From: Amy Myer <Amy.Myer@arun.gov.uk>
Sent: 23 December 2020 13:28
To: Planning.Responses <Planning.Responses@arun.gov.uk>
Cc: Daniel Vick <Daniel.Vick@arun.gov.uk>
Subject: FW: Y/126/20/DOC - Land East of North End Road - UPDATE AND REQUEST FOR EXTENSION OF TIME 27th Jan 2021

Subject: Y/126/20/DOC - Land East of North End Road - UPDATE AND REQUEST FOR EXTENSION OF TIME

I have now had chance to fully review all the conditions and information submitted within this DOC application. There are outstanding matters with a number of these (as set out below) which will prevent us from being able to discharge them at this time, and rather than refuse them, we wanted to offer you the opportunity to provide some revised information and an Extension of Time to resolve these matters.

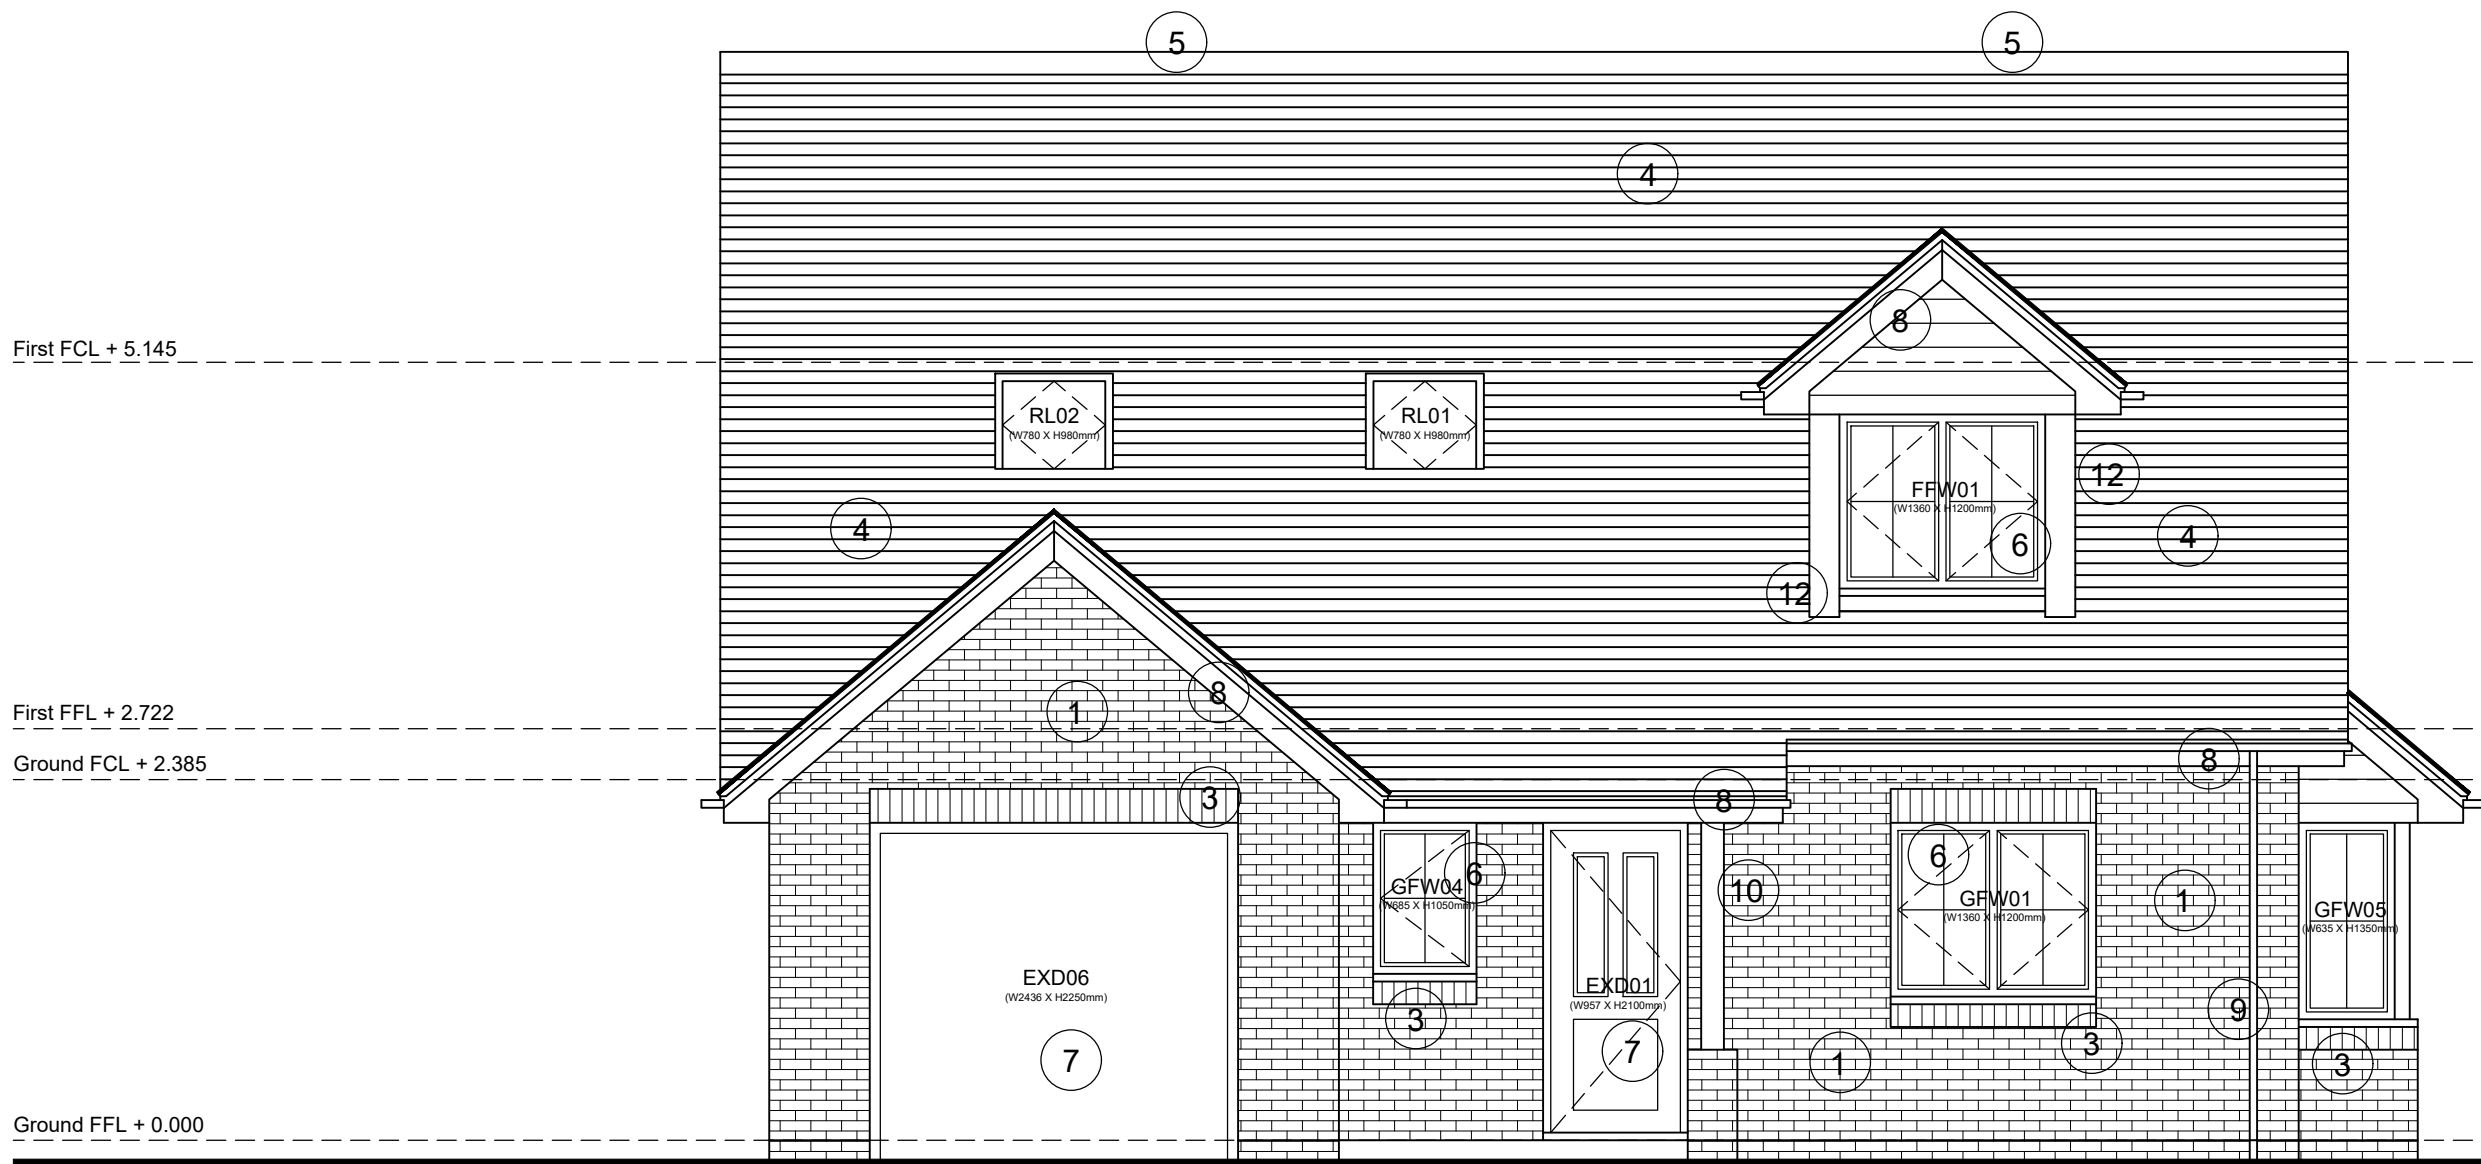
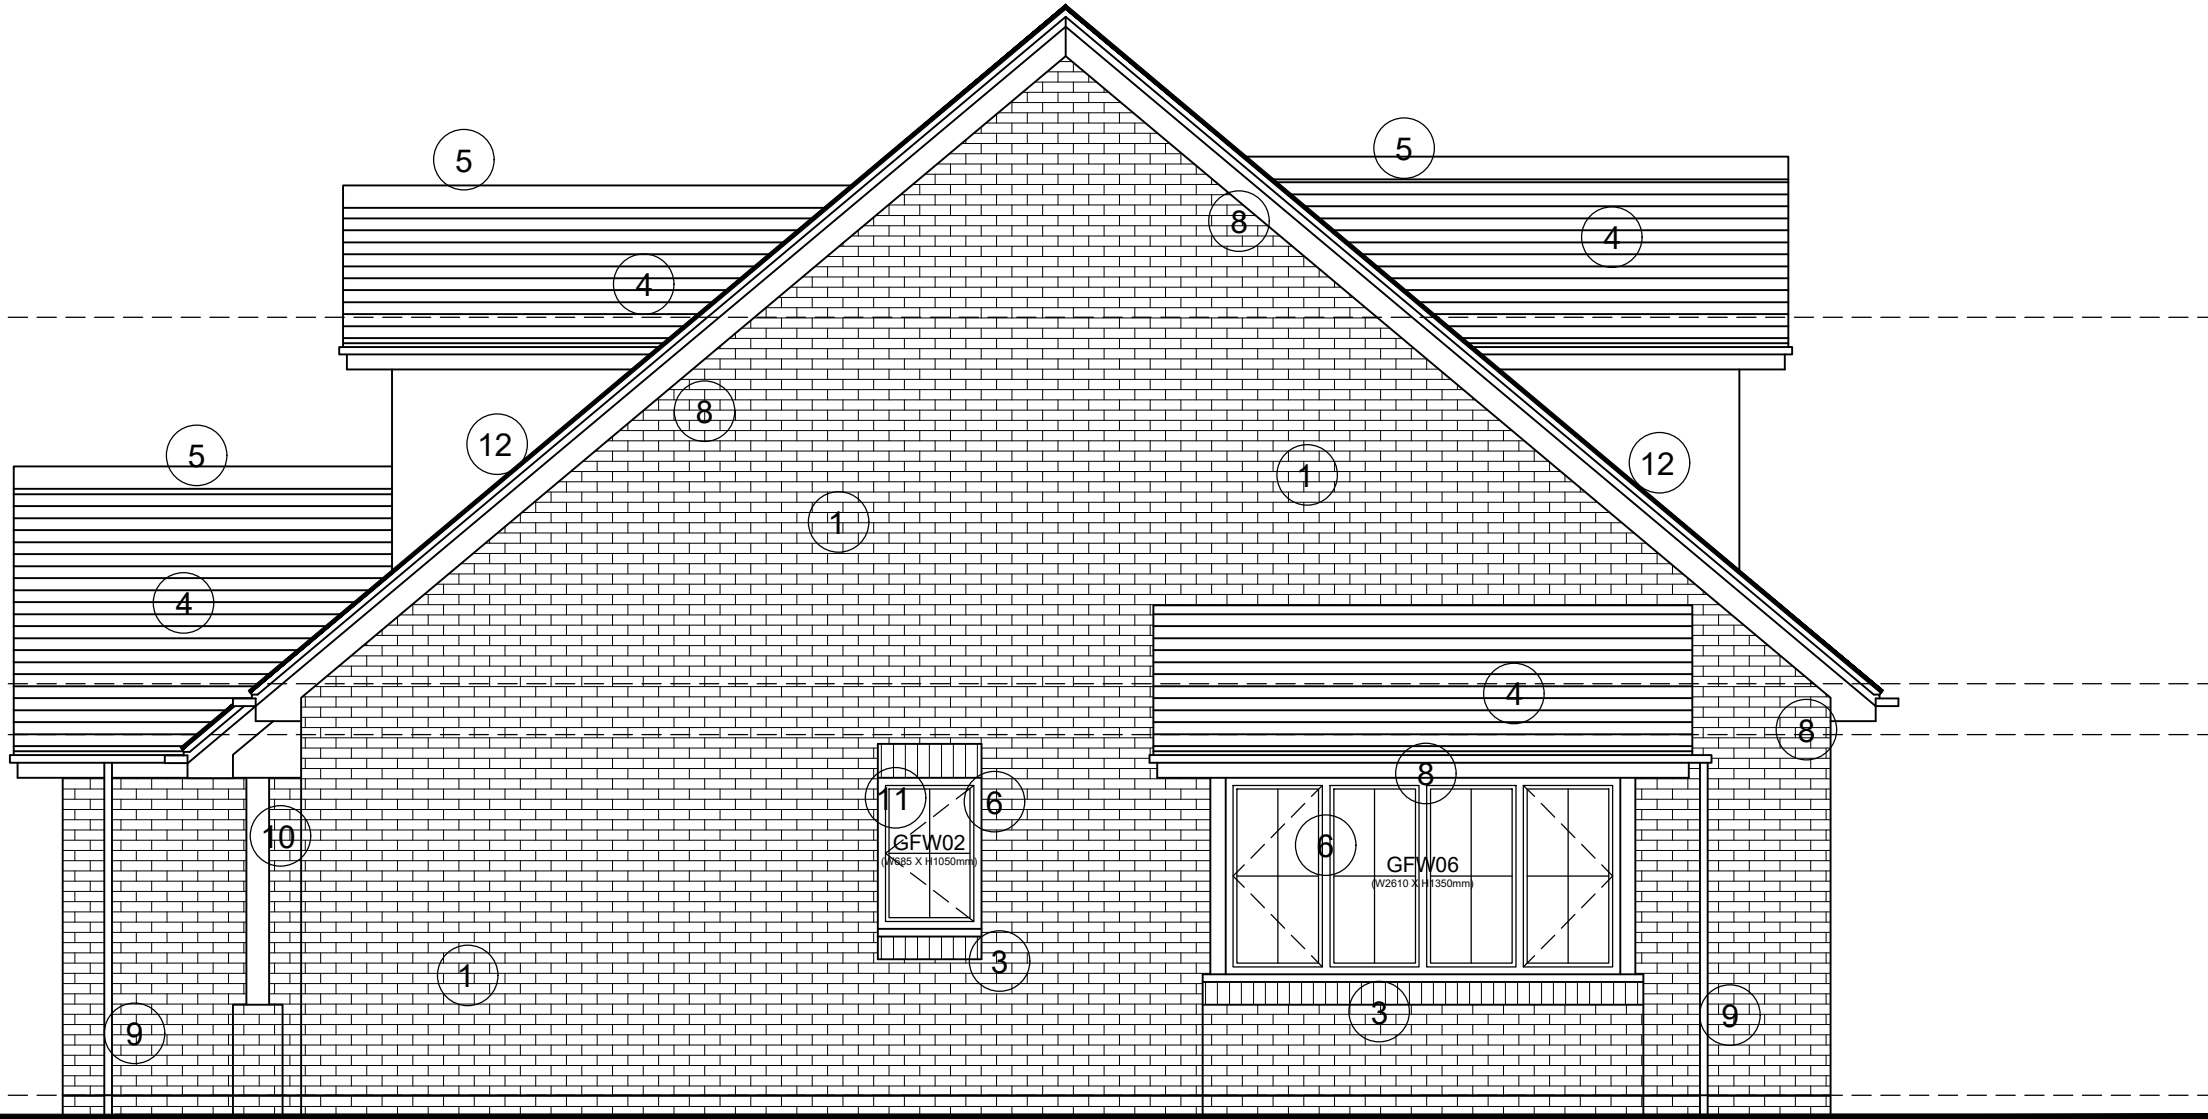
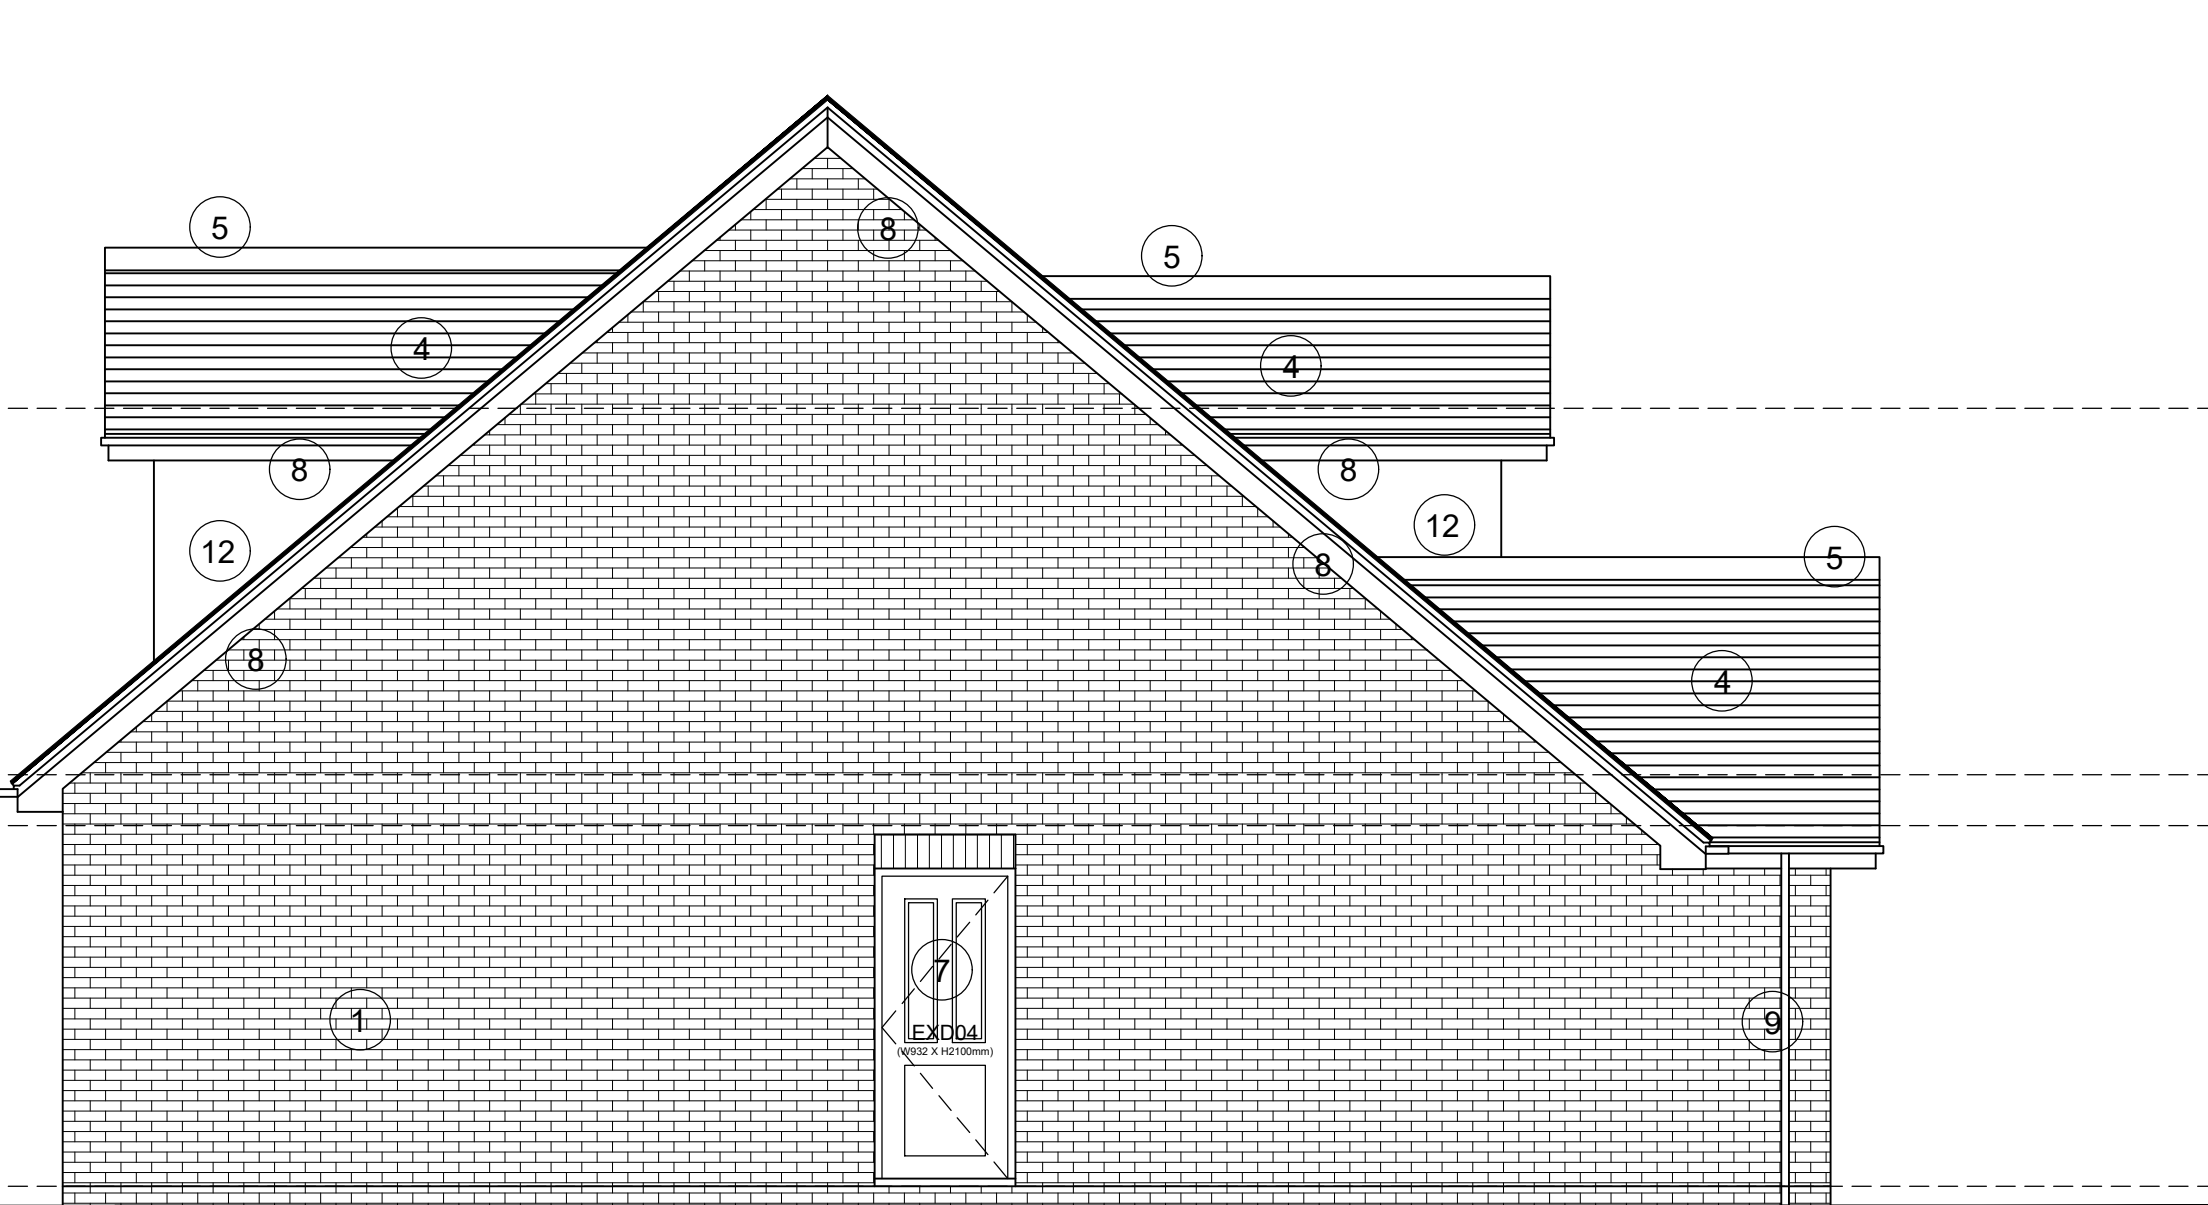
Condition 12 – materials – the proposed elevations specifying the materials are different from the approved elevations in both design and materials shown (e.g. fenestration/gable end detailing shown and flint indicated etc.). These elevations need to match to be approved, since the acceptability of the scheme depended on the design and materials proposed at the time. The only thing that needs to be specified in the drawings at this stage for the DOC is the materials. You should also provide a document with images showing the spec of the materials. If you want to change the actual design or proposed materials indicated on the approved drawings, then this will need a separate appropriate consent.
